Portishead Branch Line (MetroWest Phase 1)

9.18 ExA.CWR.D3.V1 – Appendix 2 to Applicant's responses to Written Representations submitted at Deadline 2

Subject Response to Objections Raised by Project Name MetroWest Phase 1 DCO

CTC on Behalf of ETM, Manheim etc

Appendix C: Proposed Highway Measures Drawings

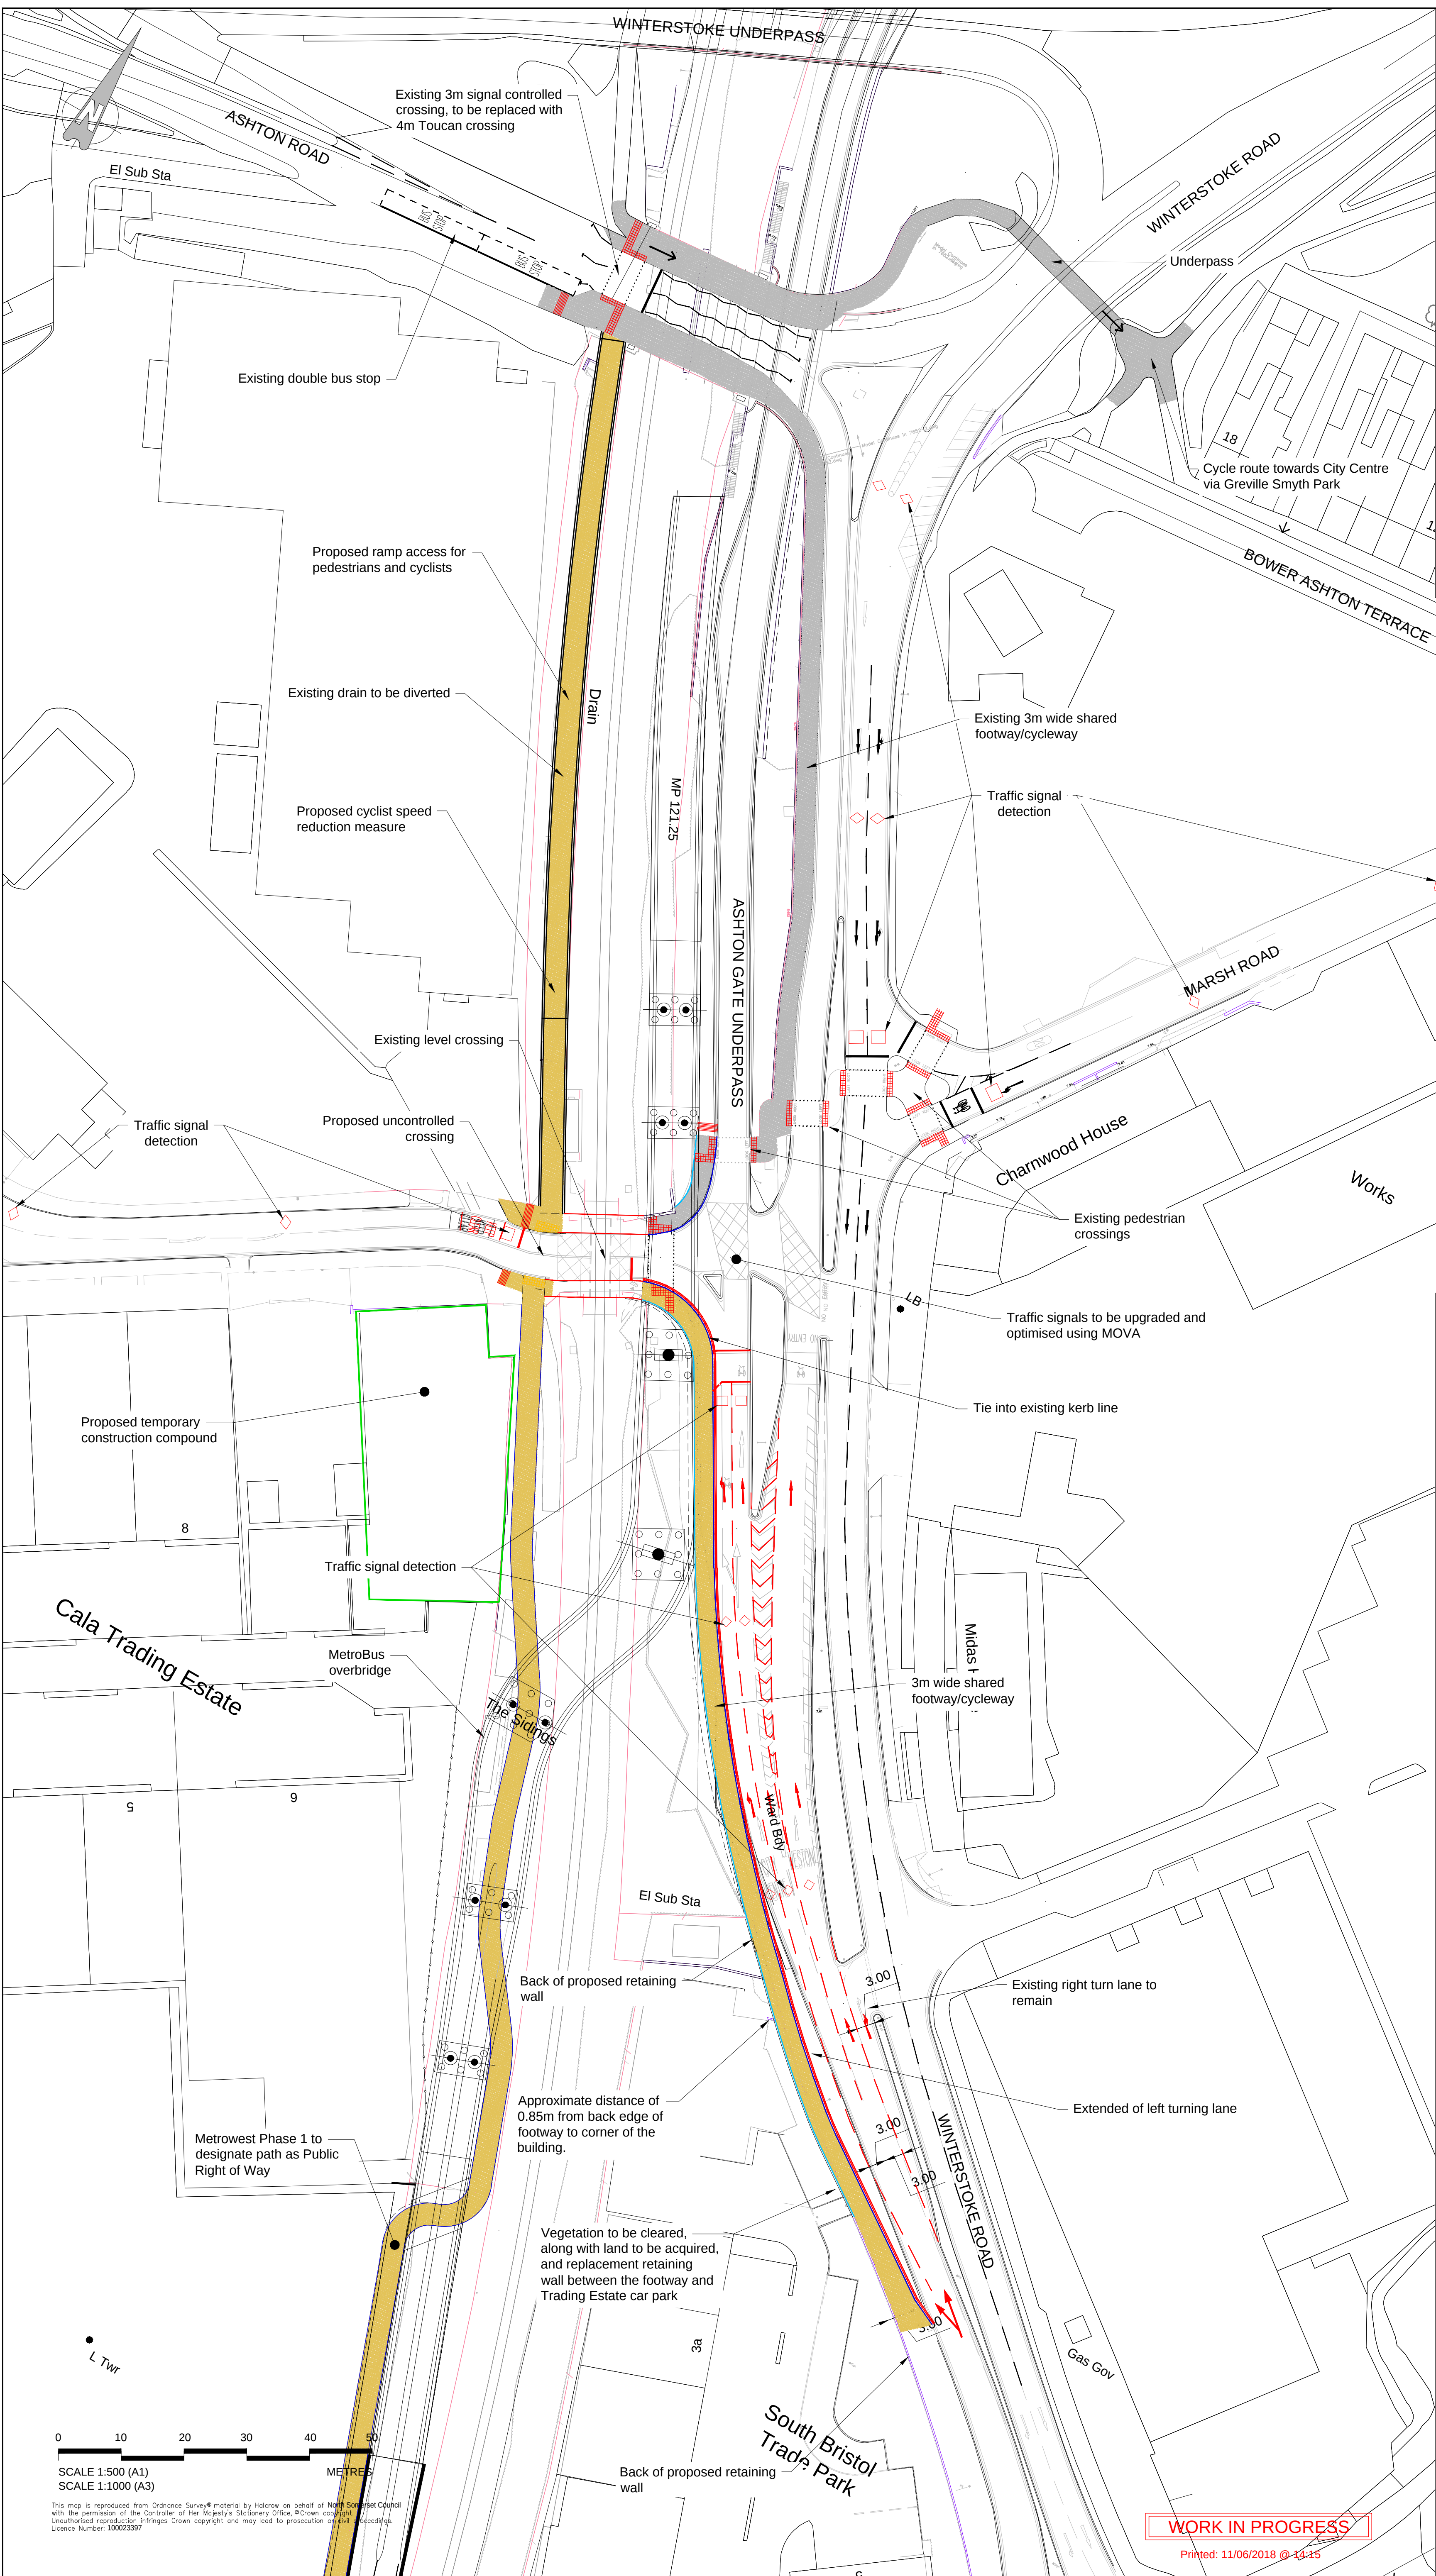
"The impact of increased closures of the level crossing is illustrated in technical tables in the ch2m note, with raw numbers presented and little explanation or analyses of those numbers given, save to suggest that the impact of the increased frequency of closure is easily mitigated by the proposed minor improvement works.

Ashton Vale Industrial Estate. From cTc's preliminary review, even allowing for the proposed mitigation, the capacity for traffic exiting the Ashton Vale Industrial Estate is reduced by at least 30% and potentially more than 50%.

With regard to the 30-50 percent reduction in 'capacity for Ashton Vale Road, it is unclear how CTC arrive at this figure, although it seems to ignore a number of factors, notably that (1) the green time for Ashton Vale Road is currently restricted anyway by the need for the signals to service other movements, and (2) that the signals will be able to provide longer green times and hence capacity for this arm following a level crossing closure, particularly under proposed MOVA control.

It is also worth emphasising that the proposed introduction of MOVA control will provide significant betterment to the operation of the Winterstoke Road/Ashton Vale Road signals. At present green time is limited to 24 seconds in the PM peak period. MOVA would be set-up with a much more generous maximum limit which would not only enable the signals to provide a longer compensatory green time following a level crossing event, but would also generally assist egress from the Estate at other times.

Figure D8: Maximum Queue Length Profile, 2021 Do-Nothing (No Freight) vs 2021 MetroWest (No Freight) plus Mitigation, Ashton Vale Road, PM Peak Period

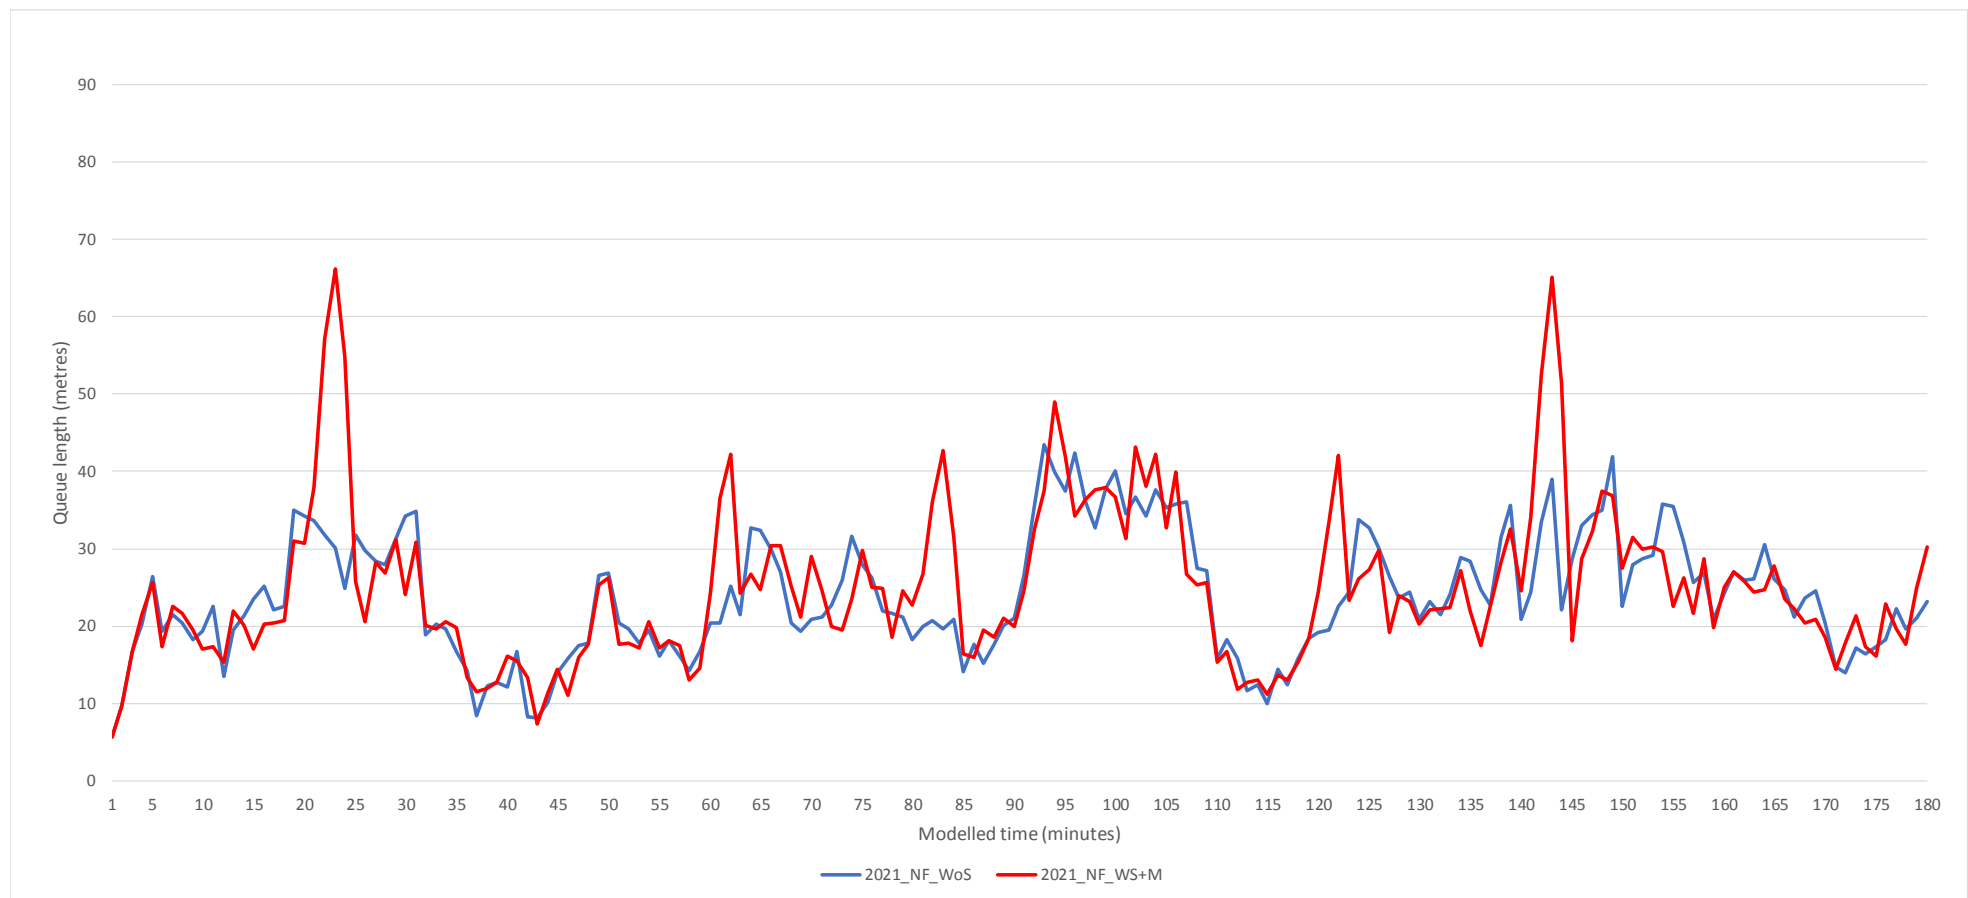
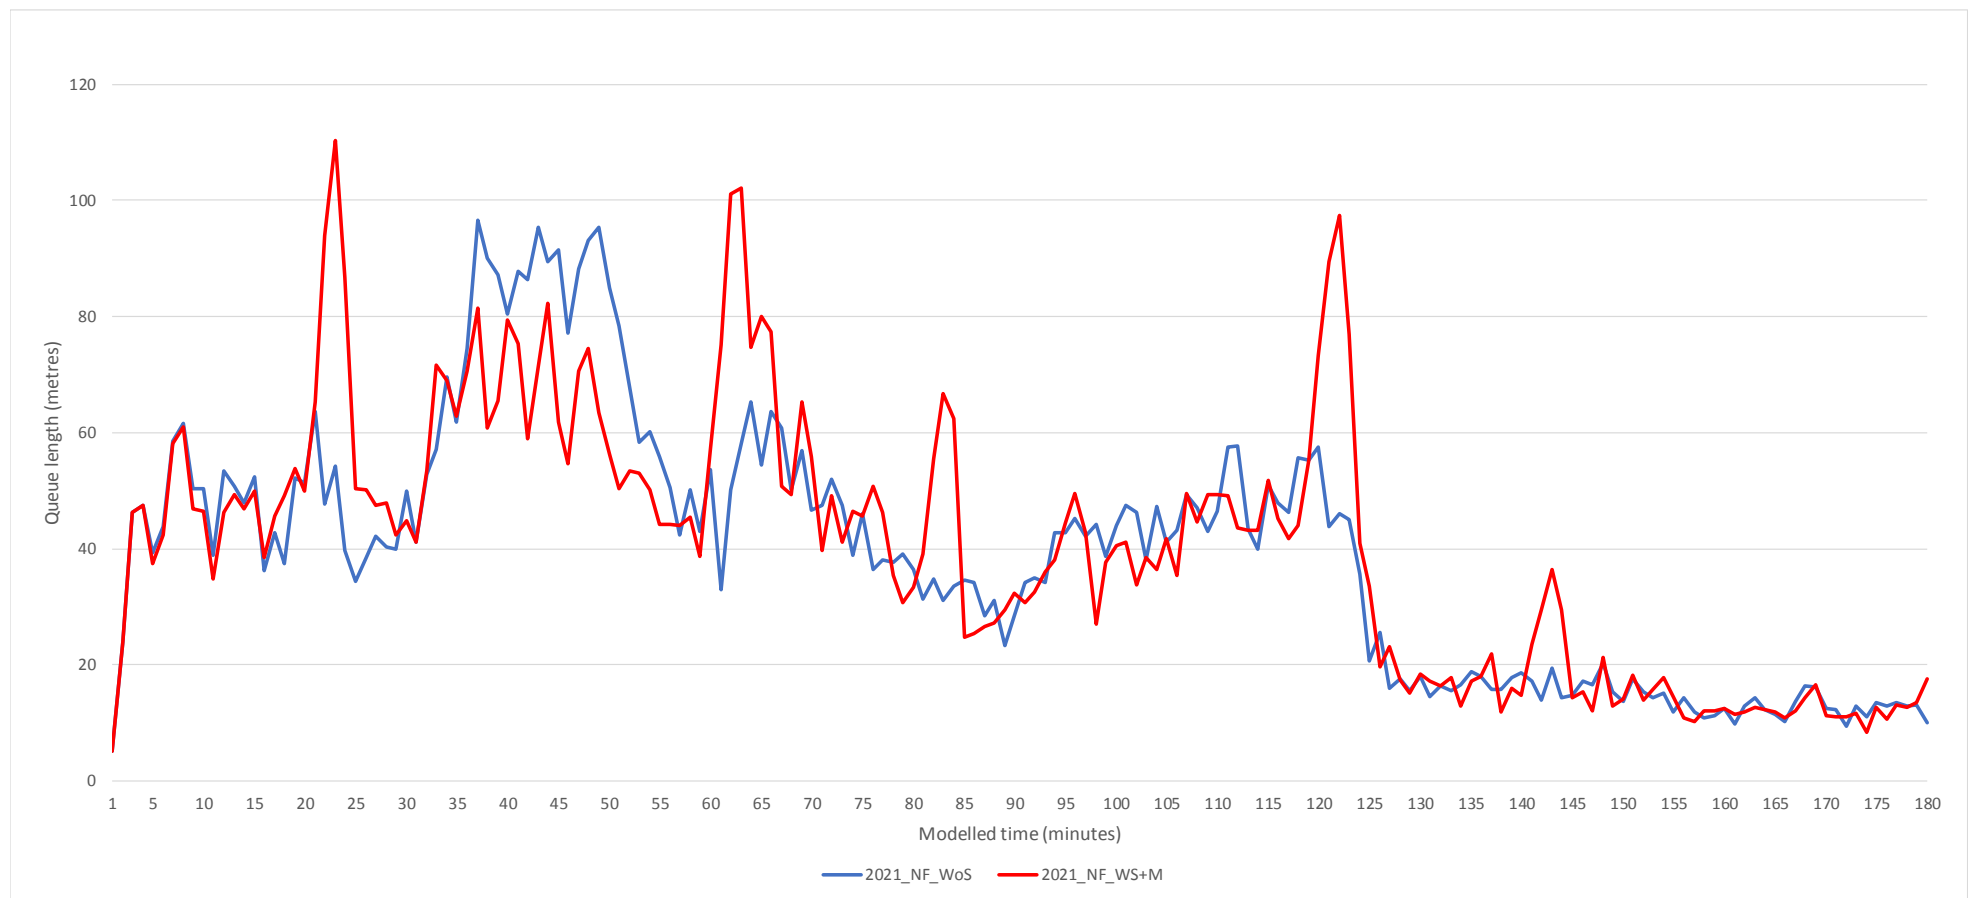
It is acknowledged that the congestion may take more than one signal cycle to clear and cycle times of the order of 160 seconds are mentioned in the report. Assuming "more than one" means at least two, this comprises 320 seconds or more. Adding to that the signal closure of 105 seconds results in significantly increased congestion for at least 425 seconds, or a little over 7 minutes. The report identifies potentially up to 5 closures per hour, or one every 12 minutes in the unlikely best-case scenario that they are equally spaced, meaning, on average 7 minutes of substantially increased congestion will be following by 6 minutes of relatively free flowing conditions (as current).

- Queue lengths during the PM peak period are expected to extend to a length of circa 100 metres (from a current length of around 50-60 metres). This is consistent with the LinSig assessment which indicated that the predicted queue length change would be from 68 to 113 metres;
- The average delay experienced by drivers during the PM peak hour (5:00-6:00pm) as a result of the MetroWest scheme (assuming no freight in either the base or scheme) is only 10 seconds more than at present. This is because, although some vehicles will experience higher levels of delay during the three level crossing closures during this hour, this only account for a small proportion of time (less than 10 per cent of the hour). As such, the majority of vehicles will experience current or, because of the introduction of MOVA, lower levels of delay compared to current levels.

Taking all this into consideration, the absolute worst-case extra delay experienced by a vehicle on Ashton Vale Road would be circa a minute and a half (165 minus 70 seconds). This assumes that this vehicle is already in the queue or arrives just as the level crossing closes. However, the vast majority of vehicles will experience much less than this, since the level crossing will be open for circa 90 per cent of the time and many vehicles will exit with very little delay at other times, with the result that the average delay over the course of the PM peak hour would be significantly lower and nearer to the 10 seconds predicted by the micro-simulation modelling assessment.
